**From:** [Tessa Bond](#)  
**To:** [HPCNuclear](#)  
**Cc:** [Andy Coupe](#)  
**Subject:** Hinkley Point C Non-Material Amendment No.4 - Response from Somerset County Council  
**Date:** 04 September 2020 15:53:30  
**Attachments:** [Somerset County Council response to Hinkley Point C Non-Material Amendment 4.pdf](#)

**Hinkley Point C (Nuclear Generation Station) Order 2013, made 18th March 2013:**

**Application for a Non-Material Change in relation to the Hinkley Point C Permanent Development Site  
Consultation under Regulation 7 of the Infrastructure Planning (Changes to, and Revocation of, Development Consent Orders) Regulations 2011**

**Date:** 4<sup>th</sup> September 2020

Site layout Plan (Operational)
Regulation 5(2)(o)

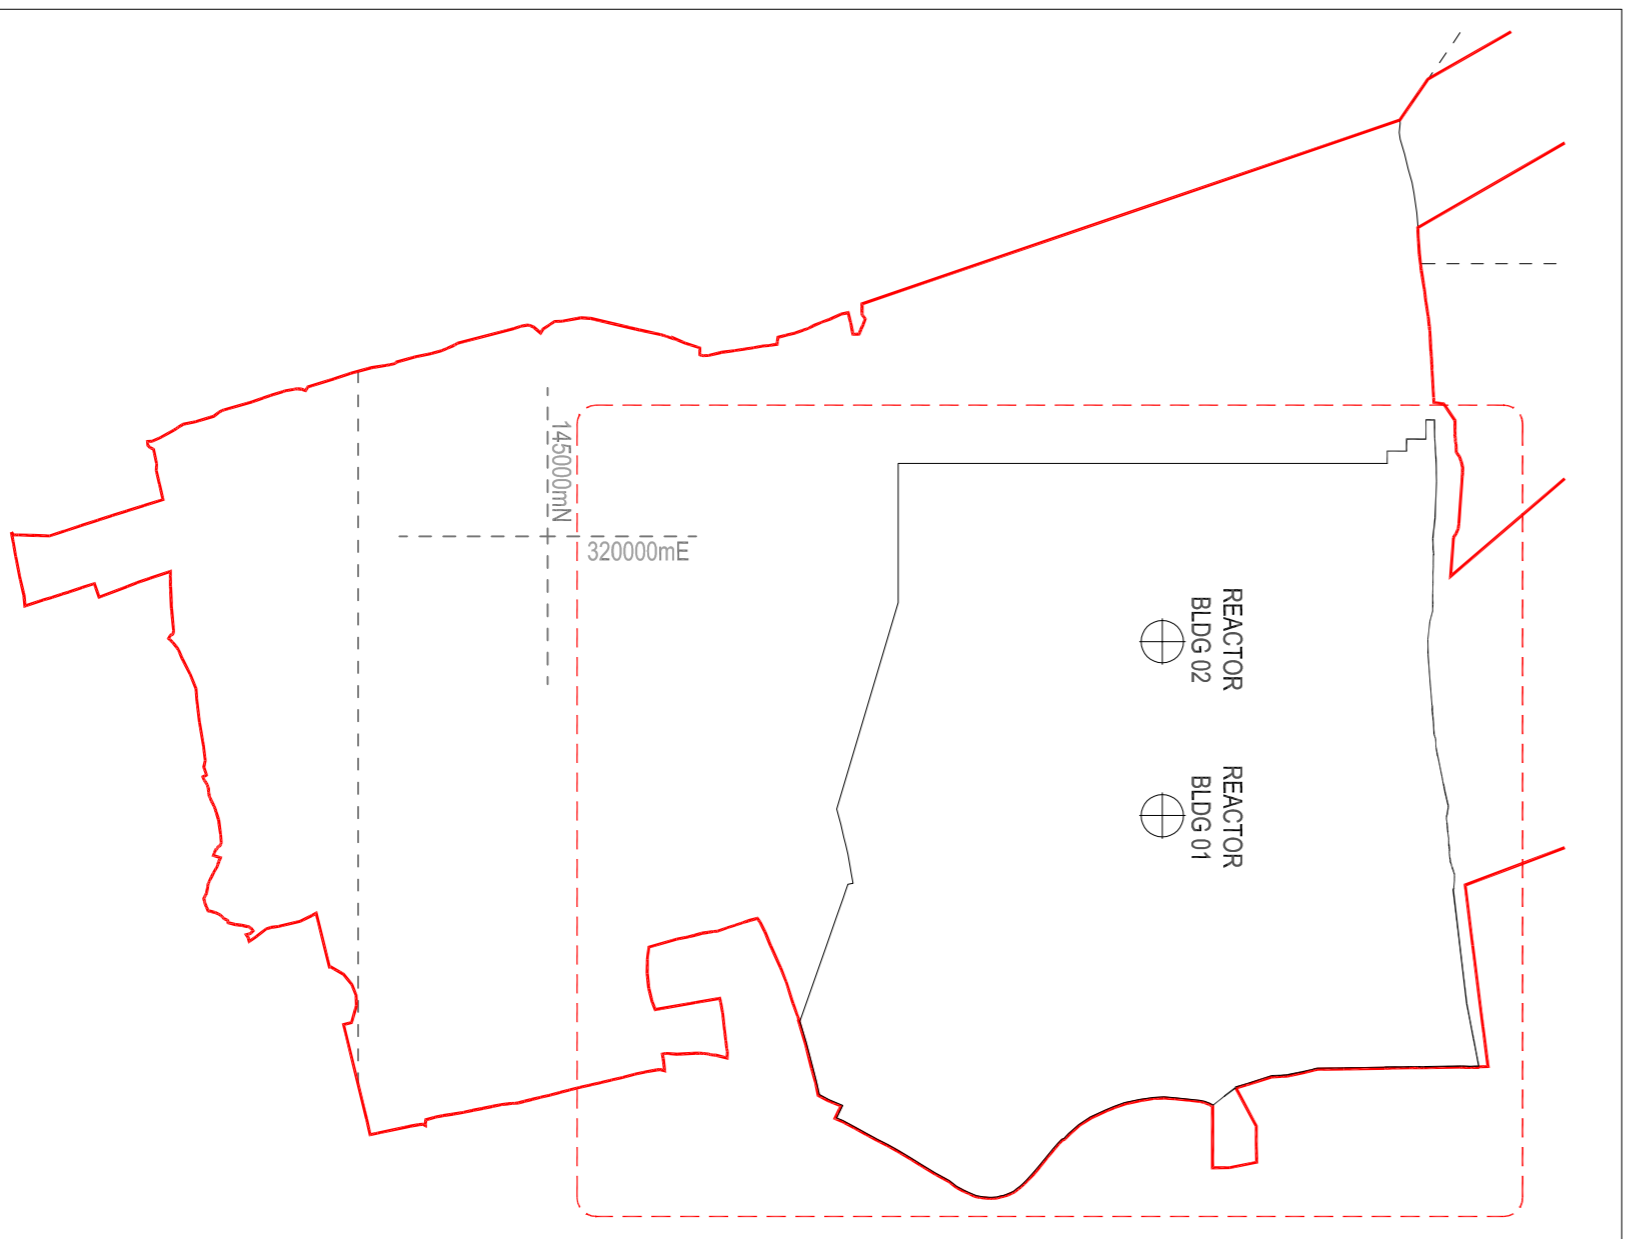
We understand that the applicant is proposing the removal the Entry Relay Building from the Site Layout Plan and transfer the functions (which related to the receipt of small packages or deliveries for the Operational Service Centre) to the newly proposed Off-Site Delivery Checkpoint.

In respect of the Off-Site Vehicle Search Area, the applicant is proposing to remove the Off-Site Vehicle Search Area from the Site Layout Plan. The footprint of this building would be left vacant by the removal of this building and would not be occupied by a replacement structure. The building's functions would be replaced within the proposed Off-Site Delivery Checkpoint.

In reviewing the submitted plans, it appears that the proposed turning head, located south of the newly proposed Off-Site Delivery checkpoint building, would remain. However, it is currently unclear whether this also applies to the previously approved lay-by configuration. Confirmation from the applicant is advised.

It's noted that under Schedule 1 Part 3 (Approved Plans) of the currently approved DCO, there is included Highway Plan Ref. HPC-GEN124-R1-RFC-DRW-000046 Rev 01. This plan still includes details of the Off-Site Vehicle Search Area; and it is therefore suggested that this plan is updated as part of this application process to be consistent with the applicant's proposals. In addition, sight of this updated plan would add clarity to the proposed changes in this area.
